14th June 2023

**23/01233/OUT, Strategic Allocation PR6a, Land East of Pipal Cottage,
Oxford Road, Water Eaton**

I write on behalf of the Oxford Bus Company to set out our appraisal of the formal planning application referenced above.

DRAWN	CHECKED	APPROVED
PH	JDW	JDW
PROJECT No:	SCALE @ A1:	DATE:
ITB16565	1:500	13.01.23
DRAWING No:	ITB16565 - SK - 067	
		REV: H

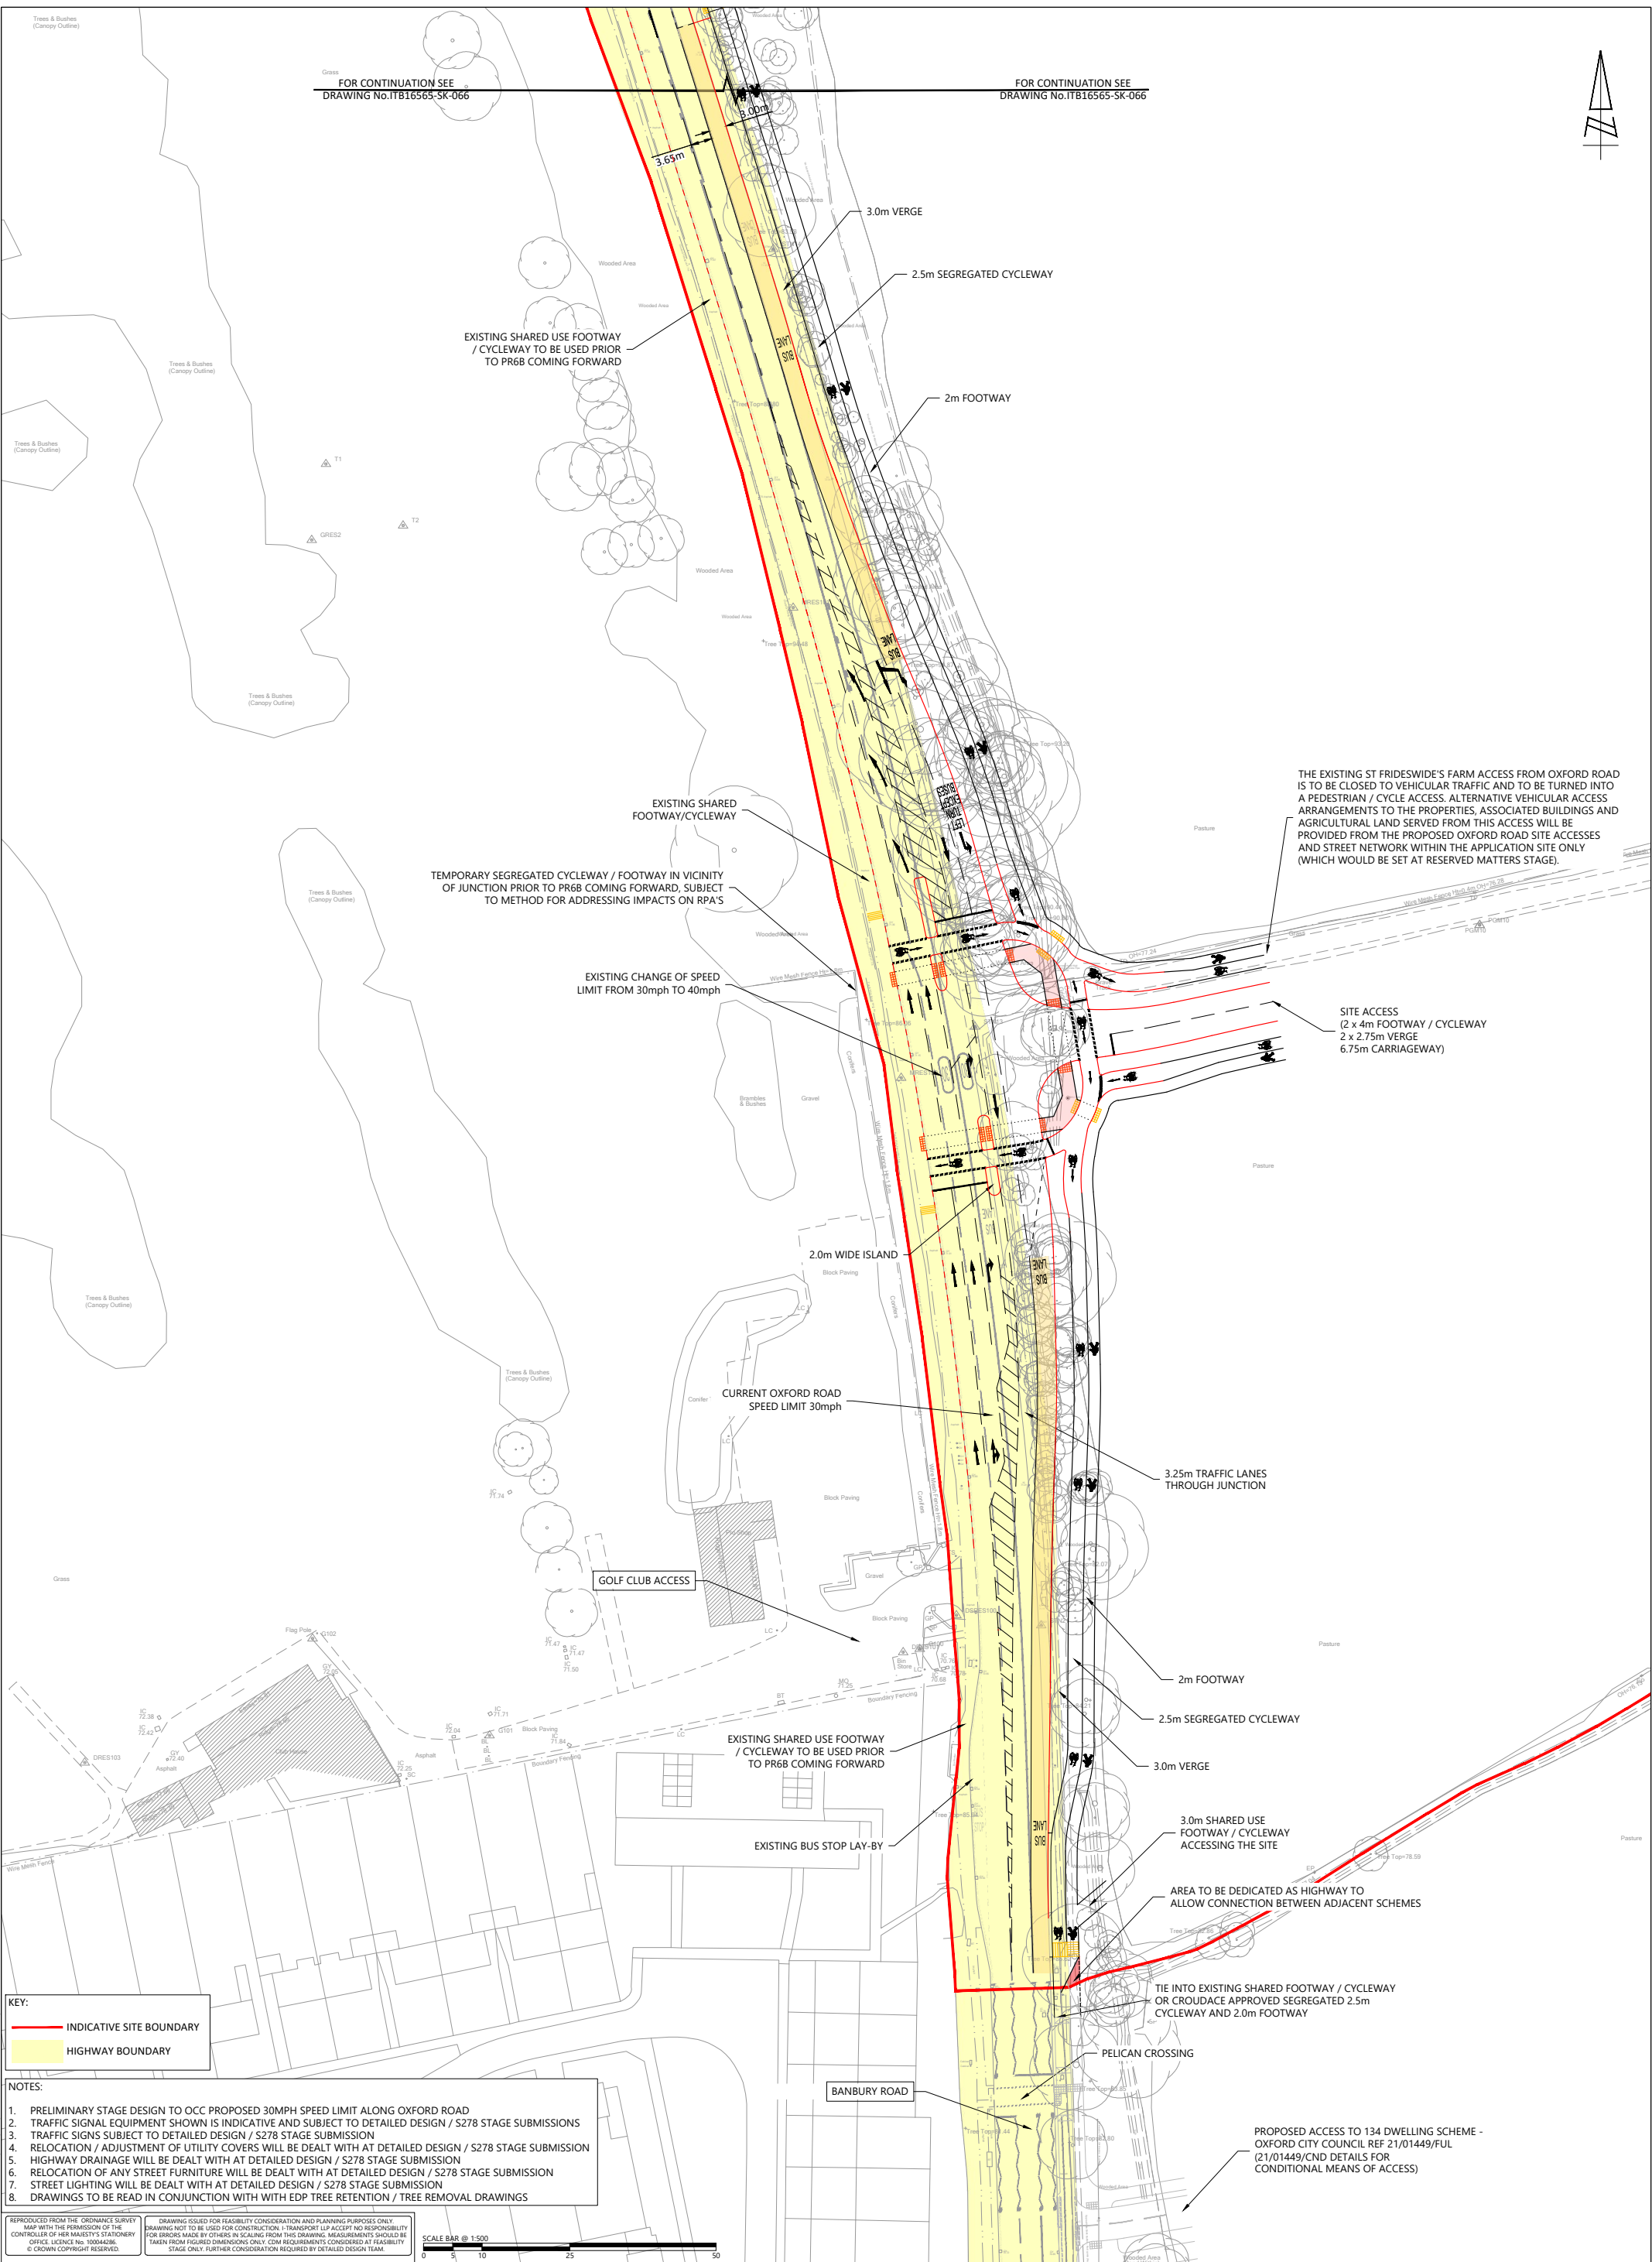
The access strategy seeks to minimise the number of junctions on the Oxford Road. A single all movements junction is proposed that is shared with PR6b to form a single new signalised crossroads. A secondary vehicular access to the north is provided for by a left-in left-out facility. As such this major development introduces only one new set of traffic signals, which serves to avoid increasing bus journey times on the corridor as a whole. This is very welcome and supported.

The northern access node is supported by a signalised TOUCAN crossing just south of the Local Centre site. Bus stops are sited immediately downstream of the crossing. This is best practice. The way that the area has been treated is especially thoughtful. The arrangement proposed means that residents wishing to use the facility either en-route to or from the bus stops on foot or cycle need not interact with local traffic at the junction. This kind of attention to detail is rare, but it strongly supports maximising the contribution of active travel and

A second pair of bus stops is provided for to the south at broadly the existing sites, that lie immediately south of the development frontage. These lie within the scope of proposals being advanced by Croudace Homes at Frideswide Farm within the City of Oxford. The distance between the proposed new stops and these is somewhat higher than would typically be expected. However, in view of the character of the road, the proposed vehicular junctions, and the way that the urban form has been designed relating directly to key pedestrian crossings, the approach taken here is certainly the correct one. It is important to recognise that the arrangement proposed keeps bus stops away from the intense activity surrounding the main signalised crossroads and CYCLOPS junction. Finally it avoids a proliferation of stops and associated delay for through bus movements.

The proposals seek to provide for the strategic improvement of pedestrian and cycling infrastructure on the Oxford Road. This ties seamlessly into separate proposals at Frideswide Farm to the south. The applicant's willingness to sacrifice a strip of land on the western boundary to facilitate this is not immediately apparent from the submitted drawings. In so doing the current constraint presented by publicly maintainable highway is overcome. A 2.5m wide LTN01/20-compliant southbound cycle track is accordingly proposed the length of the frontage physically offset from the carriageway (here, a bus lane) by a 3m verge. This allows ample space for a bus stop island to be provided, obviating conflict between waiting, boarding and alighting bus passengers. The boarder could accommodate a high-quality shelter and other relevant equipment such as Real-Time Passenger Information displays. We urge that these are provided. The continuation of pedestrian and cycle permeability to the south west boundary of the proposals through the Croudace Homes site presents direct and highly legible pedestrian access to the bus stops.
